G+L Responses Added 13-08-2025 – MILLER APPLICATION ONLY

Following a discussion between myself and Emma Mills, we appreciate the efforts made to progress the scheme. However, some matters remain unsatisfactorily addressed, but we are hopeful that a final further round of feedback and alterations should be able to resolve. These comments are:

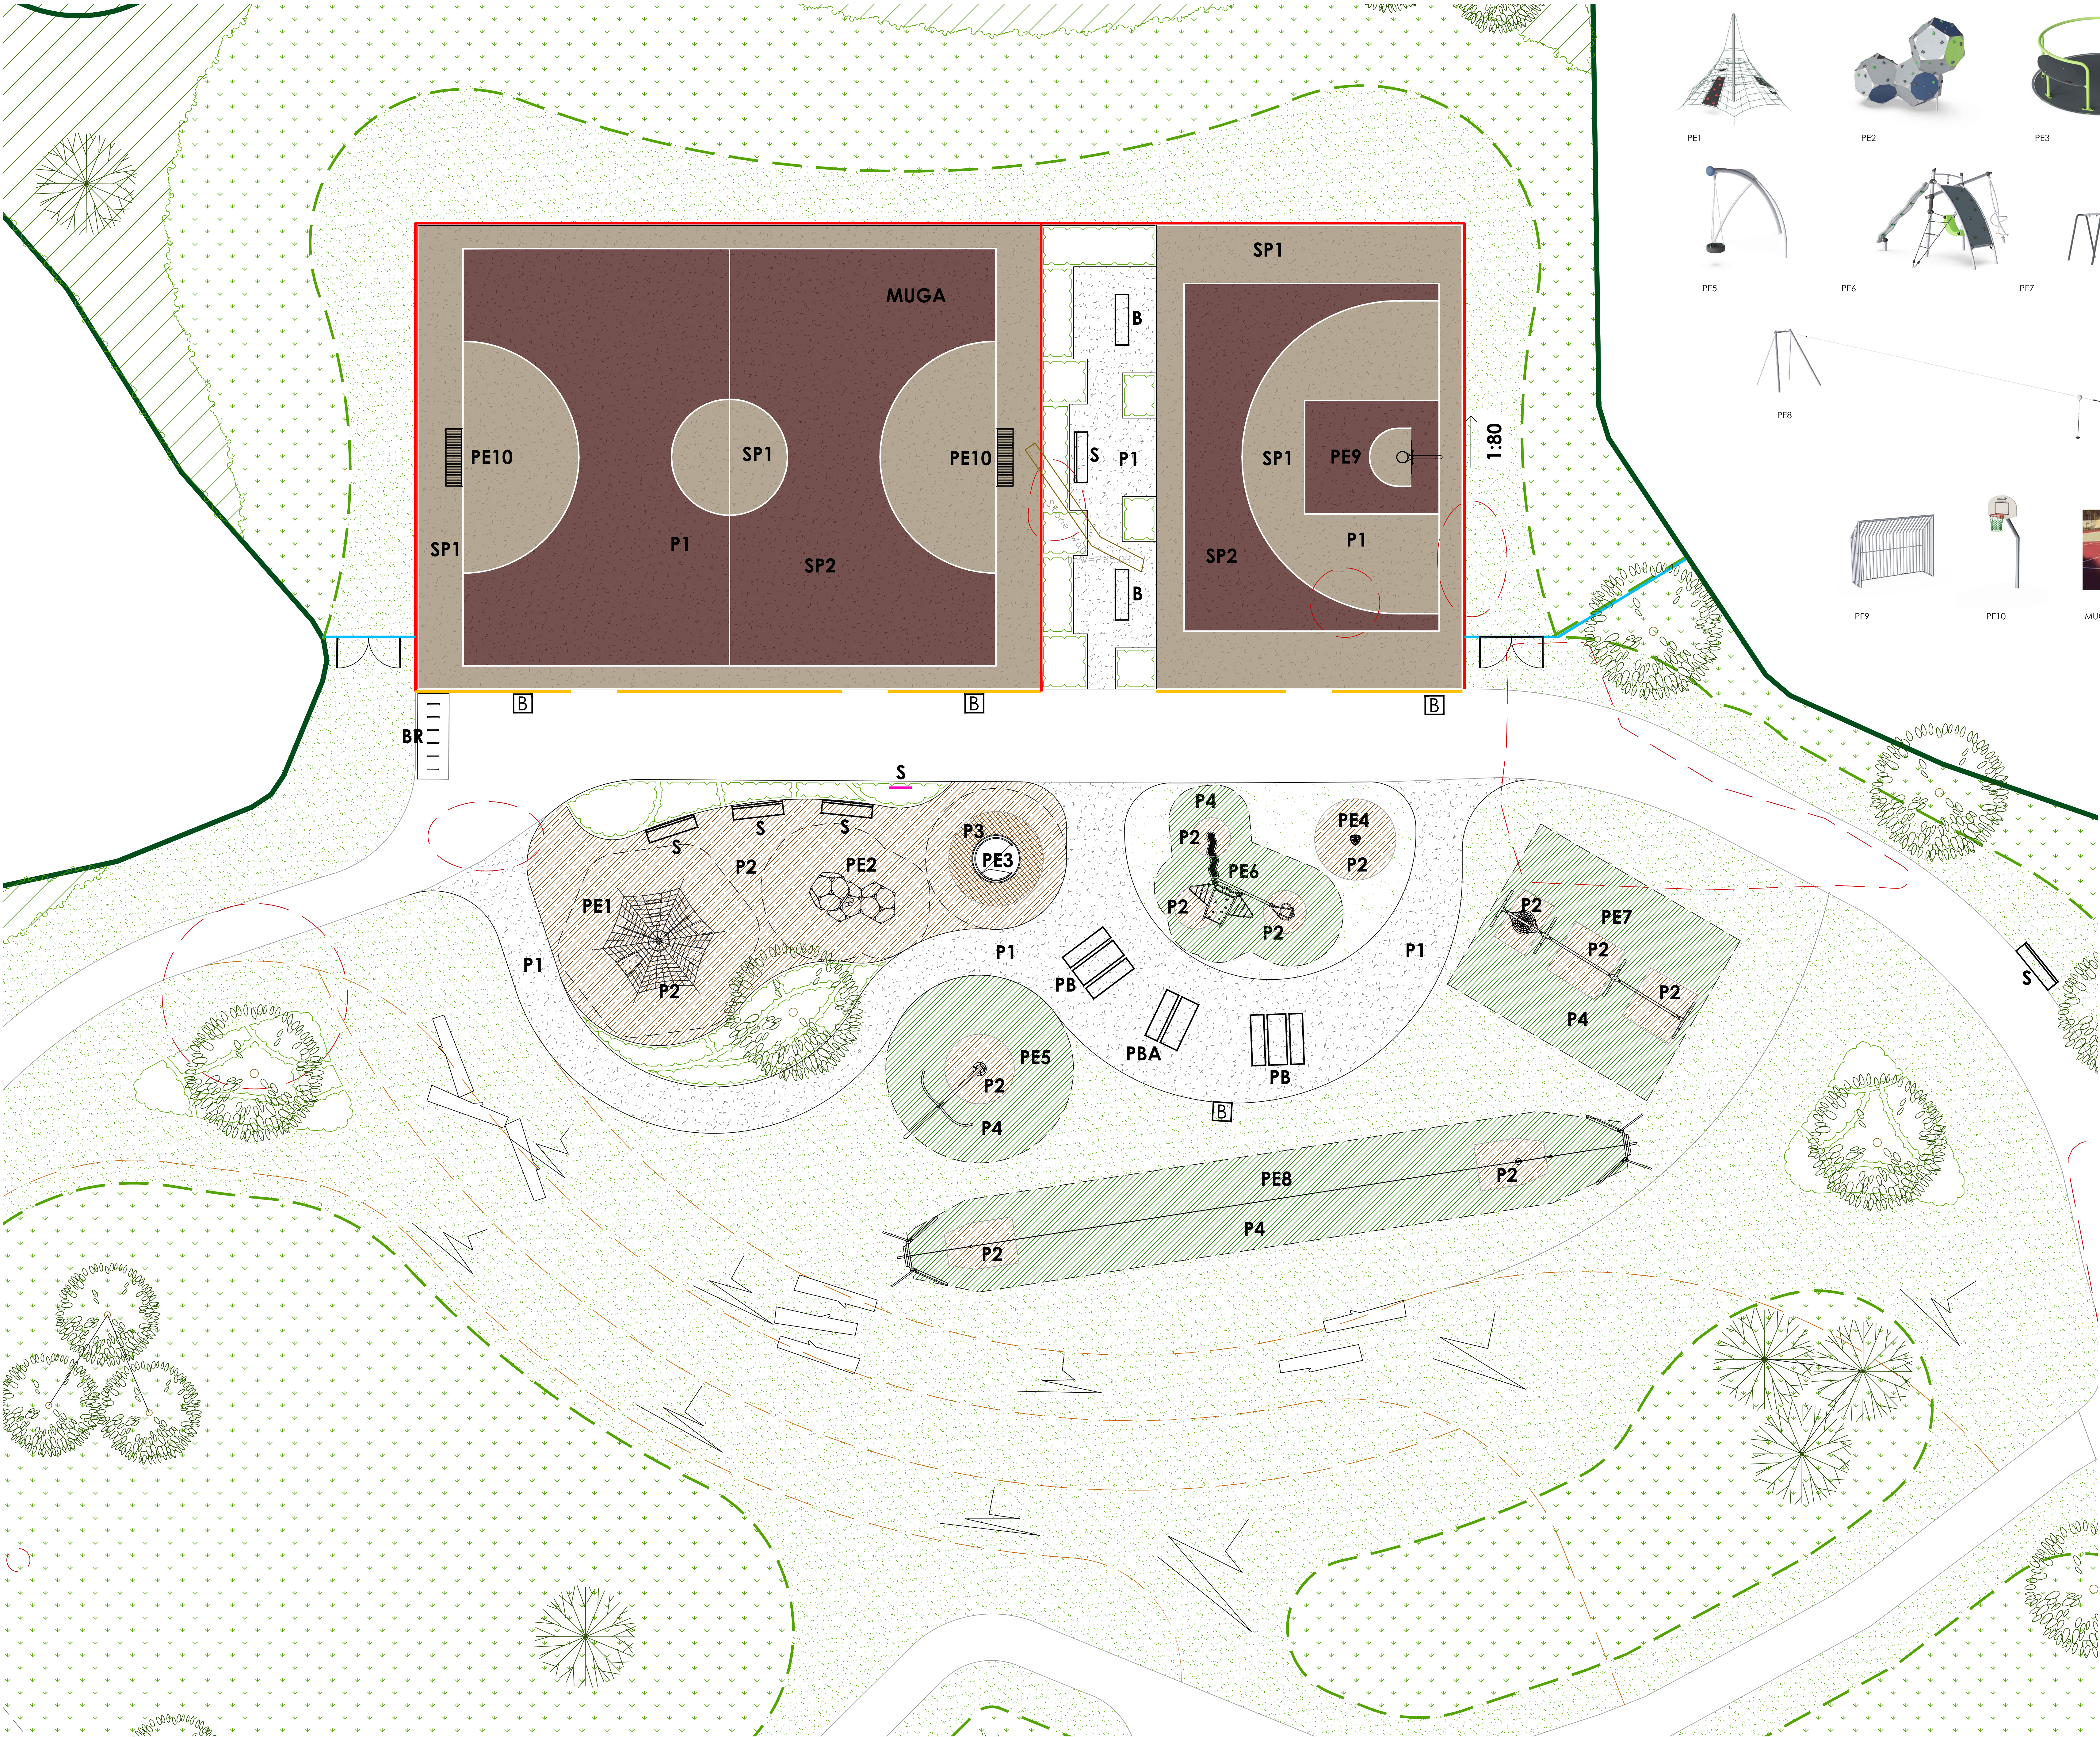
- Two entrances / exists were requested for the MUGA (anti-bully / entrapment). Replacing the single central entrance with an entrance at 1/3 and 2/3 down the length of the edge would be ideal.

- Bins have been proposed at most entrances into POS areas, which is welcomed. However, additional bins should be provided anywhere there is more than 1 bench or seat. I.e., in the middle of the NEAP are three benches: a bin next to them would be expected.

- Bike rack provided at LEAP, not NEAP. Why? Base expectation for bike rack and NEAP too.

- For the LEAP and NEAP, the general advice is to avoid wood units due to maintained issues. However, as this will remain yours / Manco, we can accept but we'd recommend looking at high quality / spec material for the long-term benefits.

- NEAP (Miller side): Better, but still issues / shortfall. See the following:
 - PE1, may be acceptable, depending on size. Do you have a product sheet that can be shared for that?

- PE3 is proposed in the LEAP, can a different (but still accessible) product be proposed.

PE5 is incorrectly detailed on key. Not 100% clear on what it is supposed to be.

- PE4 and PE6 are too basic / small pieces of equipment. Larger and more complicated units, suitable for more mature children, are expected.

Updated as requested. See GLY0043 PP 01 B.

Additional bin added by the picnic benches. Bins respaced only MUGA boundary to improve accessibility/proximity to other seating areas.

Bike rack added to NEAP.

NEAP changed to metal units. LEAP to remain timber – agreed with Emma Mills 13/08.

Product agreed with Emma Mills 13/08.

Product retained within NEAP but substituted from LEAP.

Dino Swing. Please see GLY0043 PP 01B.

Equipment substitutions agreed with Emma mills 13/08.
